16 October 2026

Lime Down Solar Park – Development Consent Order (DCO) Application

Environment Agency Examination Deadline 8 Response: Closing Statement

Title:
Figure 11.5 Rev 4: Lime Down D (BESS)
Fluvial and Surface Water Flood Risk Map

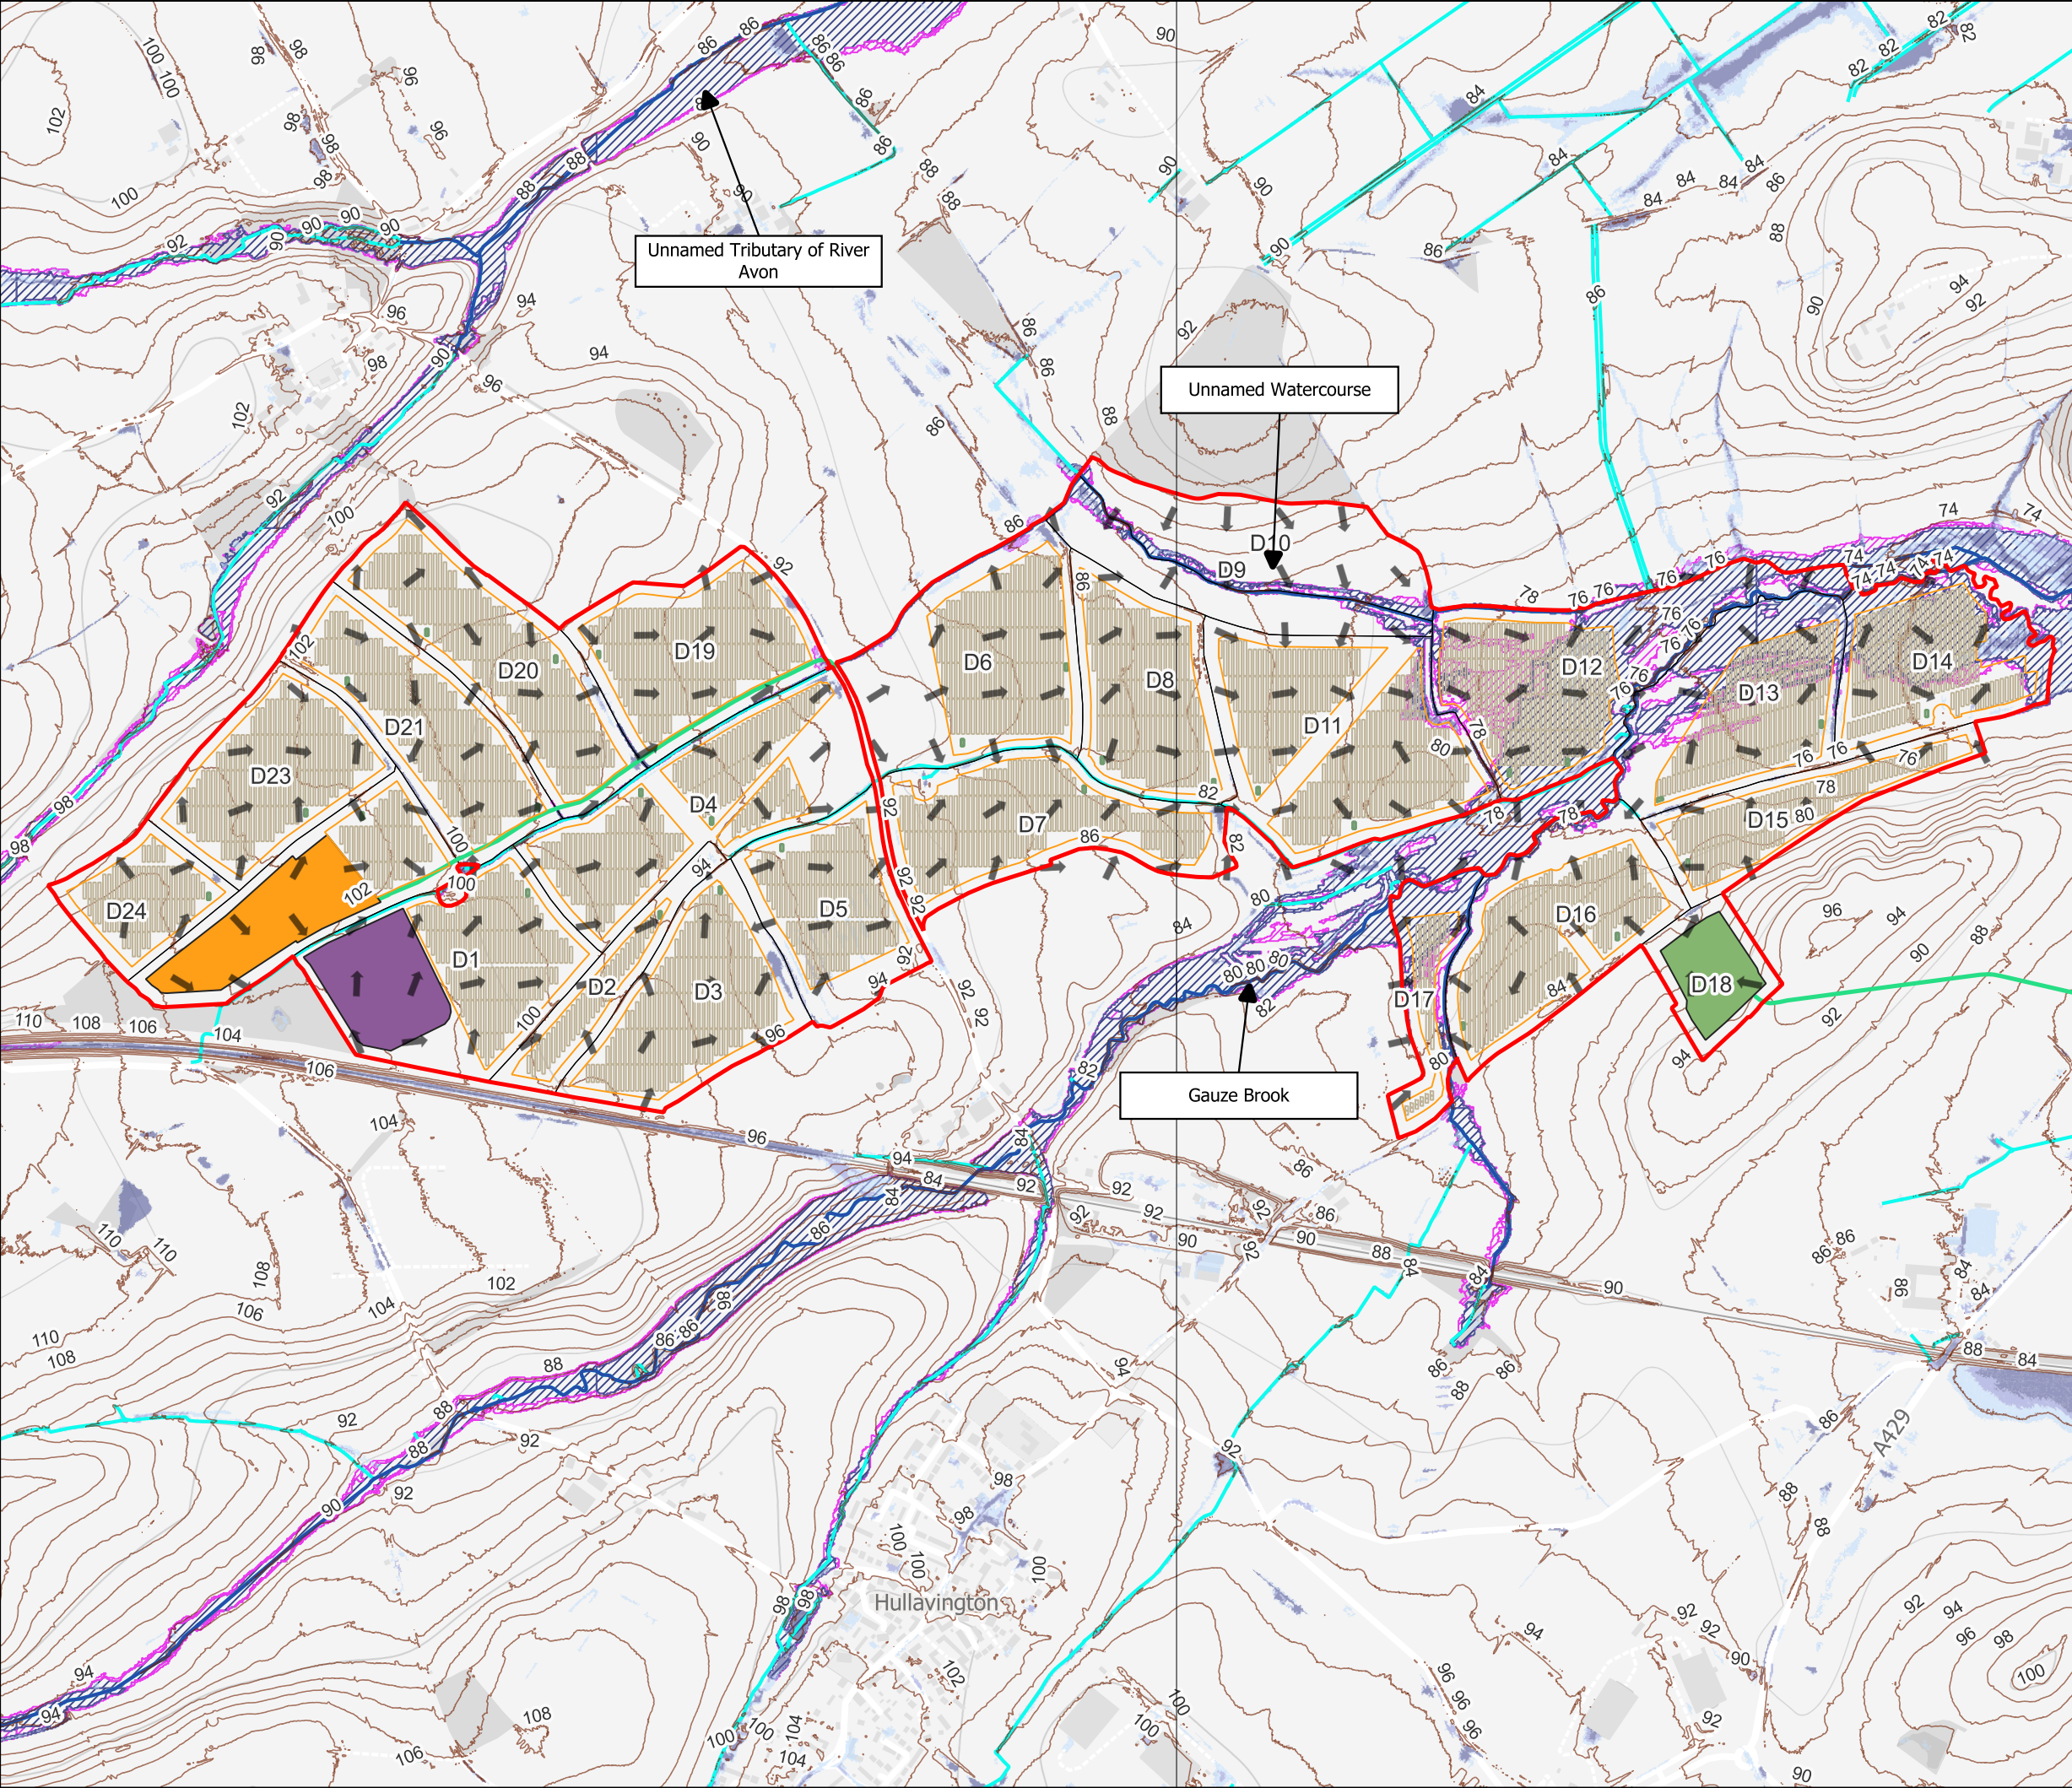
whether any storage falls under the requirements of the Reservoirs Act 1975.
EA-03	Environmental Statement Volume 3 Appendix 11.6: Flood Risk Assessment (FRA) and Outline Drainage Strategy – Lime Down D/BESS. August 2026. Revision 5 (REP5-056)	The hydraulic model outputs presented within the FRA do not appear to reflect the latest hydraulic modelling.	Agree The latest Flood Risk Assessment and Outline Drainage Strategy – Lime Down D/BESS Revision 6 (October 2026) (REP7-051) has been updated to reflect the outputs from the latest Gauze Brook hydraulic modelling.
